<b>Application Ref:</b>	3/2025/0948			 <b>Ribble Valley Borough Council</b> <a href="http://www.ribblevalley.gov.uk">www.ribblevalley.gov.uk</a>
<b>Date Inspected:</b>	07/01/2026	<b>Site Notice:</b>	07/01/2026	
<b>Officer:</b>	MC			
<b>DELEGATED ITEM FILE REPORT:</b>				<b>APPROVAL</b>

<b>Development Description:</b>	Proposed single storey side extension to form gym and golf simulator room.
<b>Site Address/Location:</b>	Lower Yew Tree Farm Alston Lane Longridge PR3 3BN

Drawing Title
Proposed Ground Floor Plan and Elevations

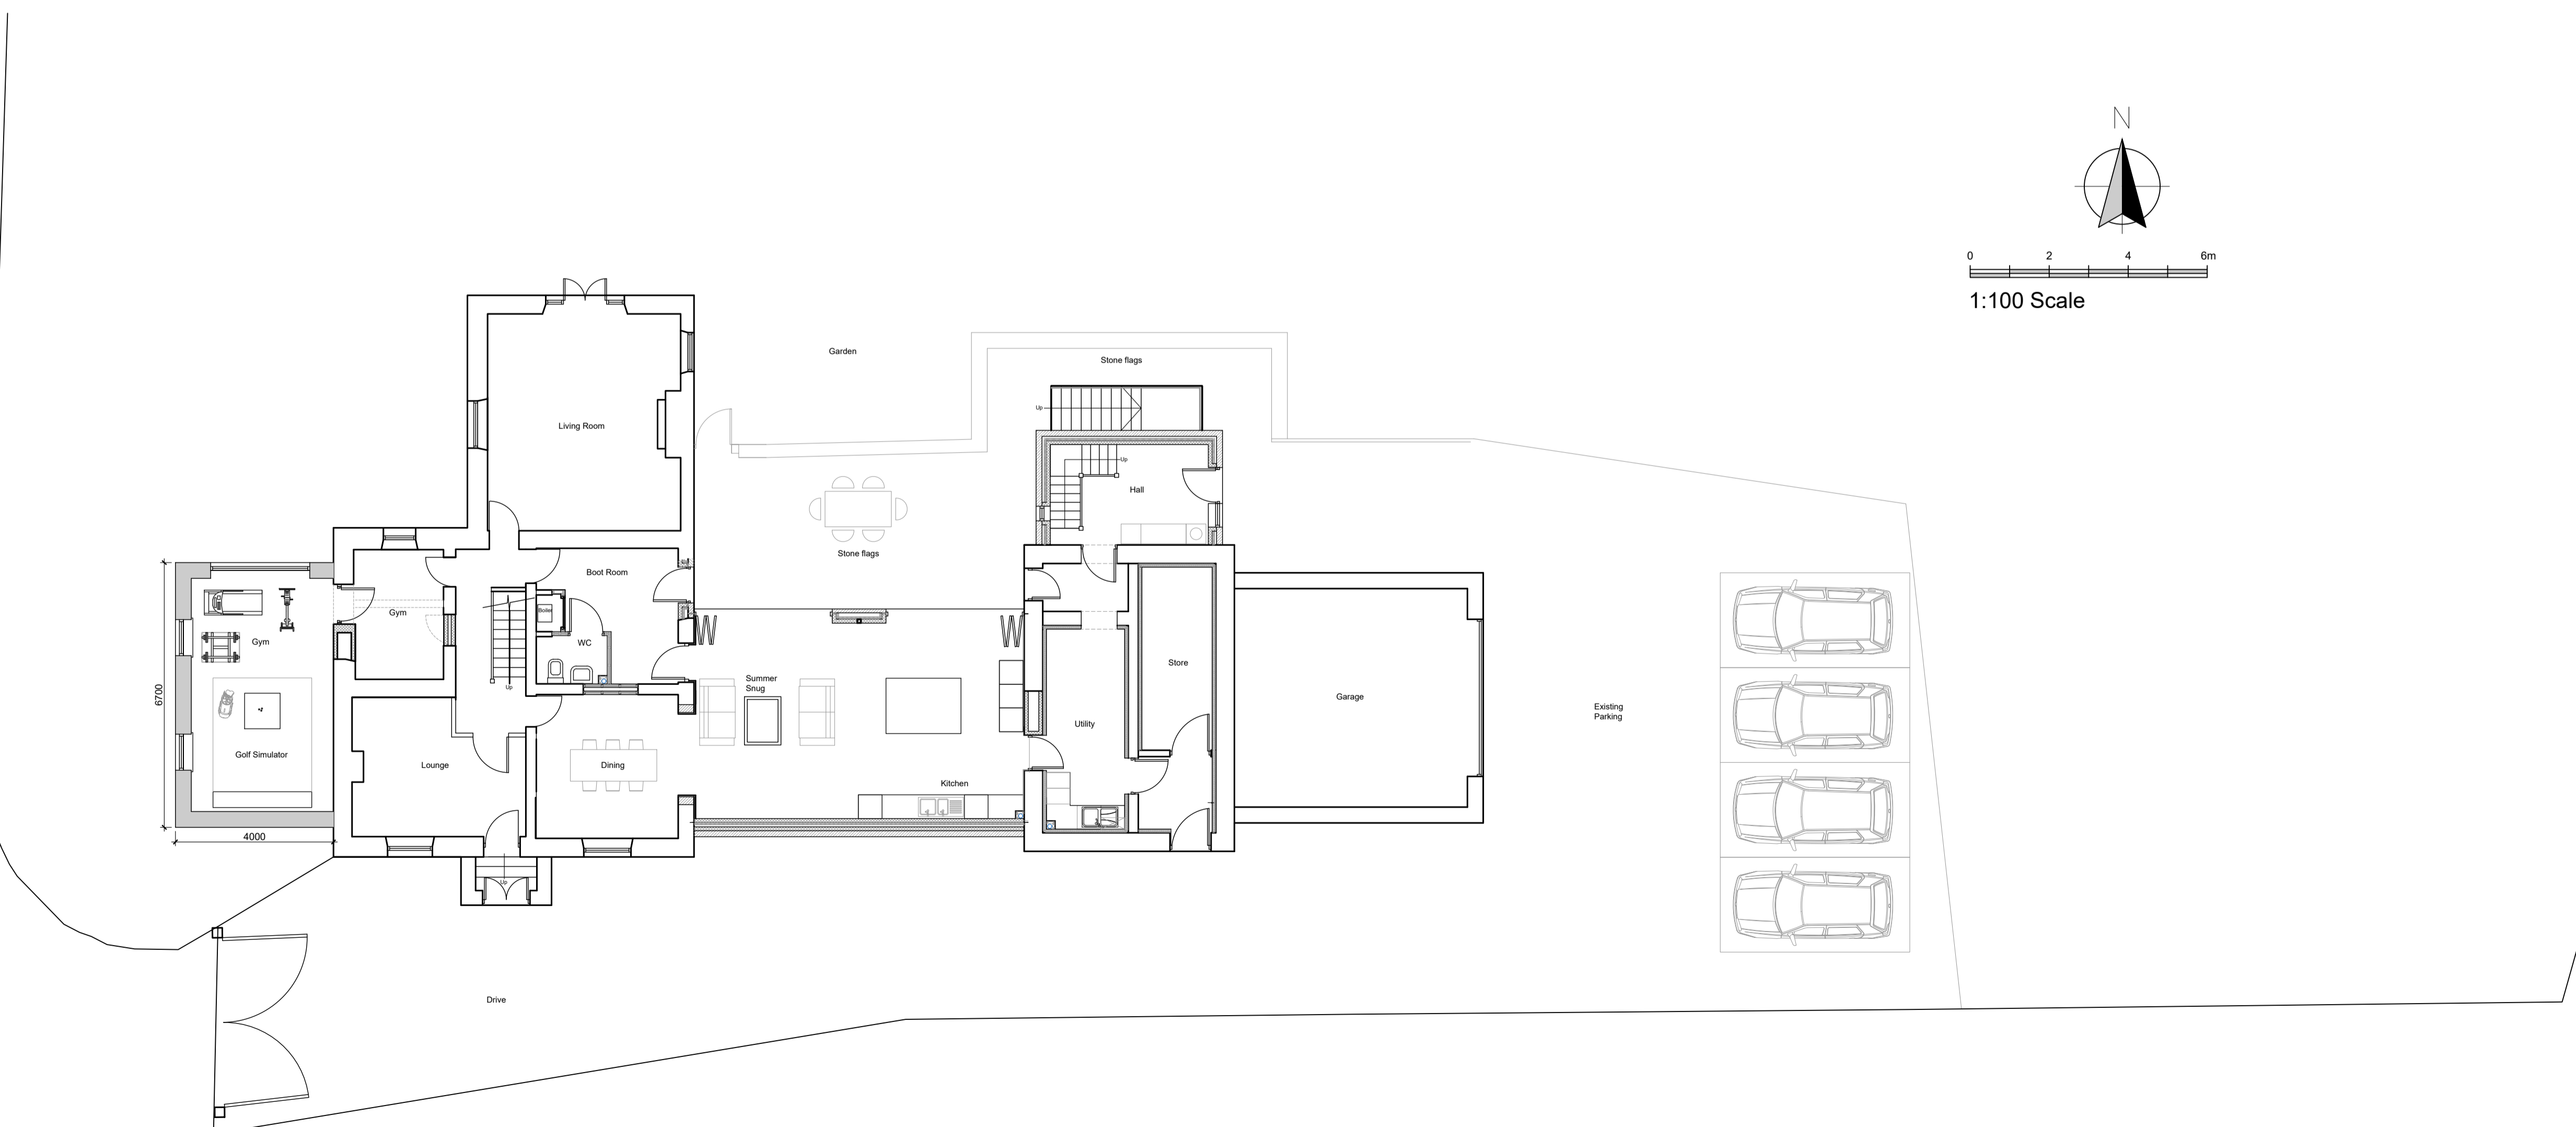
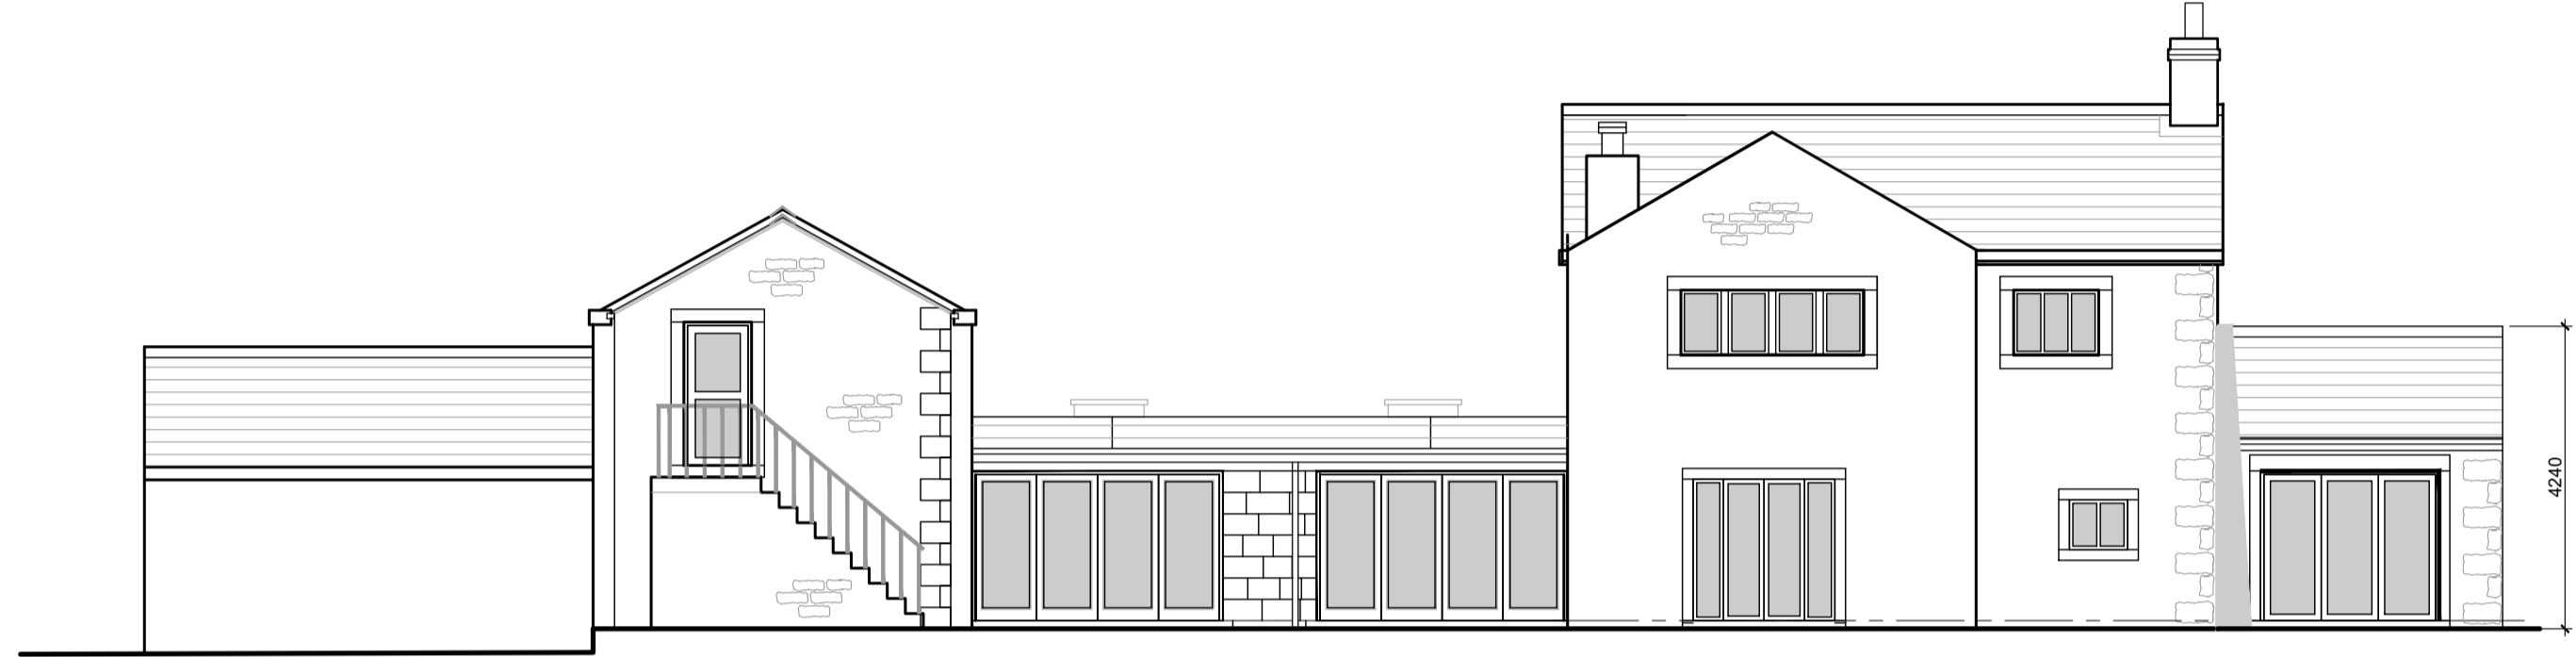
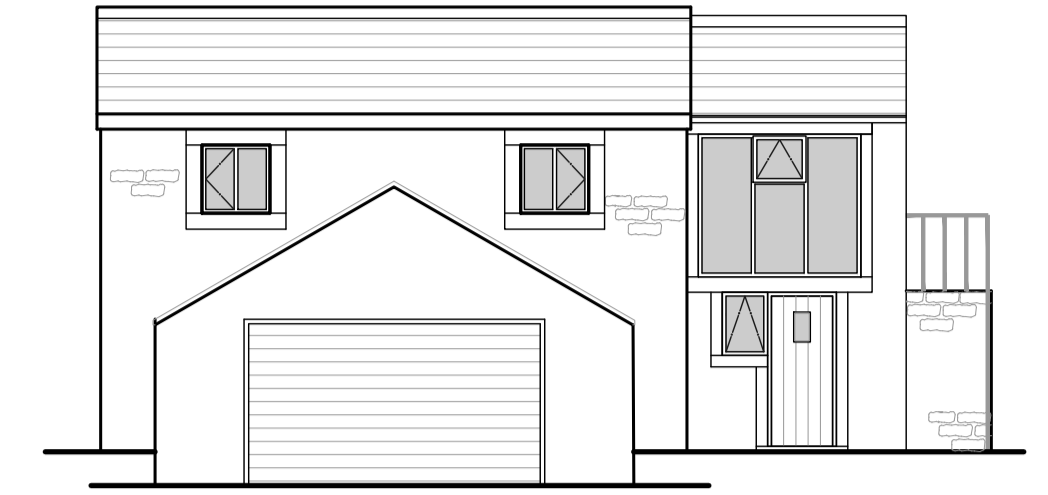
The application is for the erection of a single storey side extension to western flank wall of the main dwelling. The extension would measure 4m by 6.7m with a maximum ridge height of 4.2m. The extension would bring the building line closer to Alston Lane, leaving a minimum gap of approximately 4.3 metres between the flank wall and the western boundaries. The extension would be constructed of natural random stone to match the existing, slates to the roof to match the existing and would have two timber casement windows to flank elevation and patio doors to the rear.

It is not anticipated that the proposed development would result in any measurable undue harm upon the existing amenities of any nearby residential properties. The openings proposed to the western gable elevation and rear elevation of the extension would not have a direct line of sight with the adjacent neighbouring residential properties at ‘Yew Tree Cottage’ or ‘Gardeners Cottage’. The extension would also be sufficiently distanced from nearby neighbouring properties so as to prevent any overshadowing, loss of light or overbearing impact.

Drawing Title
Proposed Site Plan

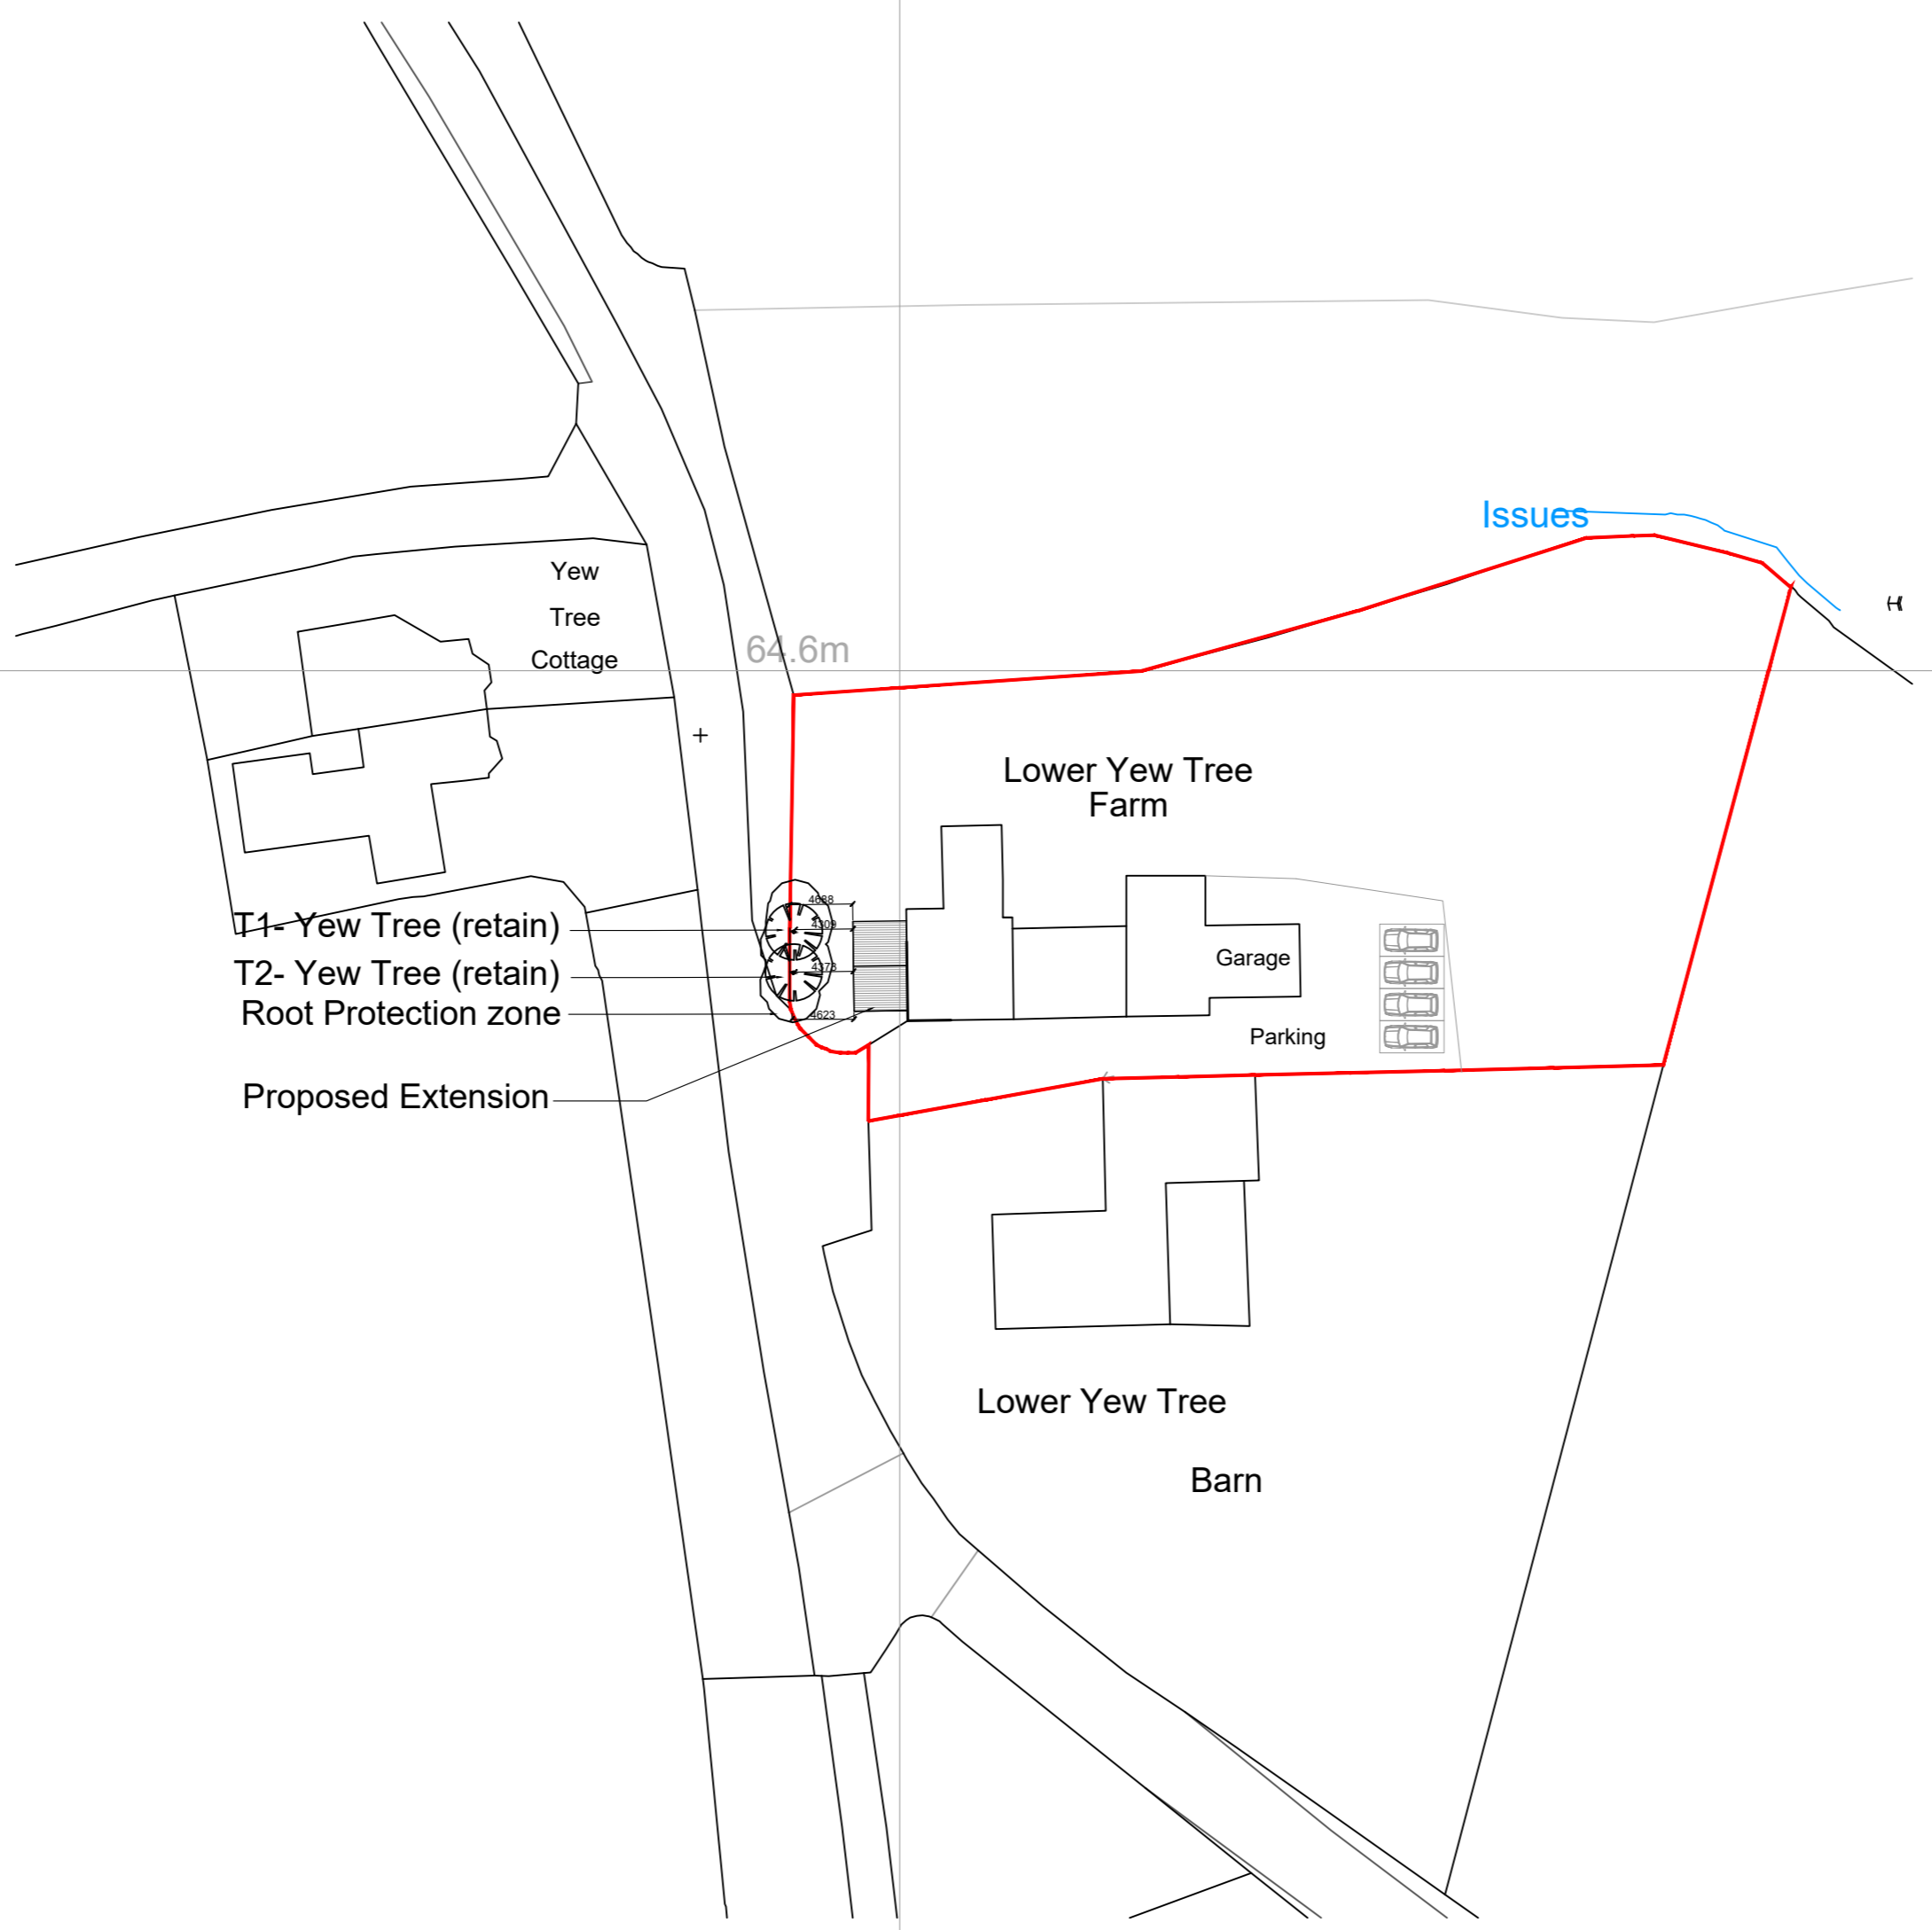
Notwithstanding the above, the extension is single storey and set down significantly from the main roof ridge. It would be visible from Alston Lane. However, it is not considered that this would give rise to any detrimental impact on the character and appearance of the rural area, nor would it appear overly prominent or incongruous due to its scale, design and external materials. The extension would also be partially screened on the approach to the dwelling from the North, which are shown to be retained on the proposed site plan.

The proposed extension would be located within close proximity to a number of mature trees which border the proposal site to the east, adjacent to the highway. The submitted site plan indicates that these trees would be outside of the root protection area of the proposed extension and as such, it is not likely that the trees would be harmed during construction or as a result of the extension.
